From: Joe Gilbert
Sent: Monday, August 25, 2008 8:53 AM
To: Kari Braniff
Subject: Young

The Young's are approved and finalized for a 4 bedroom residence on their current septic. Any New residence would require a additional septic system. Or a large modification to the current system. The Tanks of the current system are adequate for a 6 bedroom, but the drainfield is only sized for a 4-bedroom.

-  - septic line
-  - power line
-  - water line

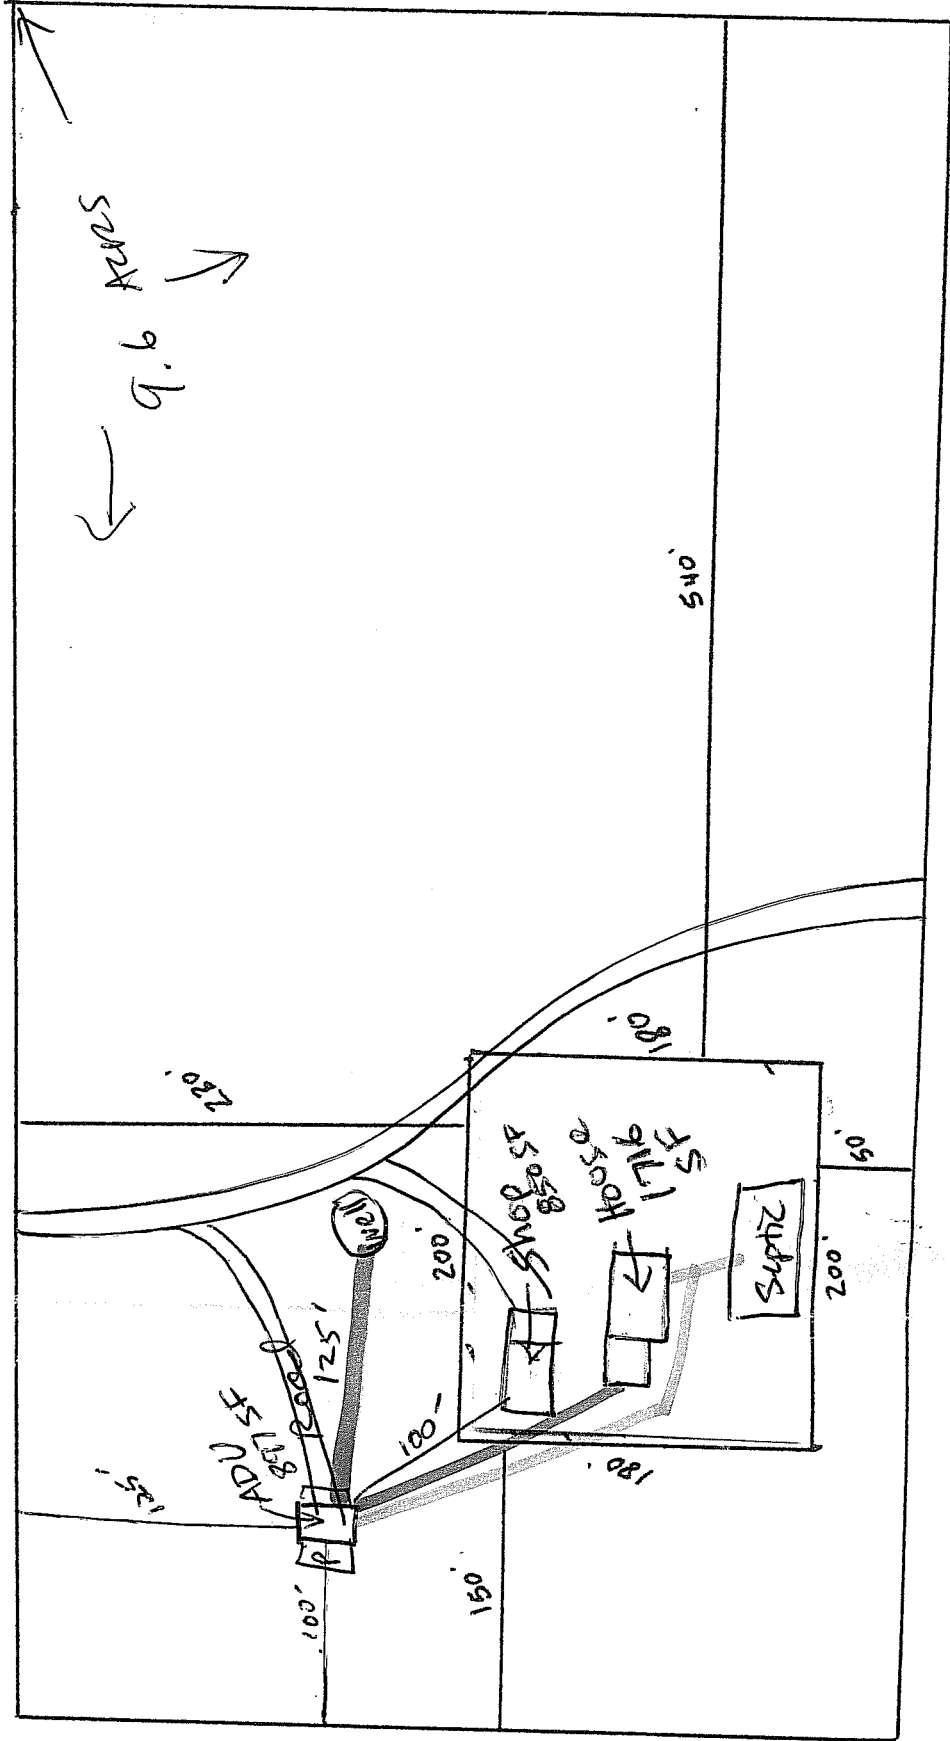
You can approve the ADU without septic, they won't get a building permit until the septic issue is resolved.
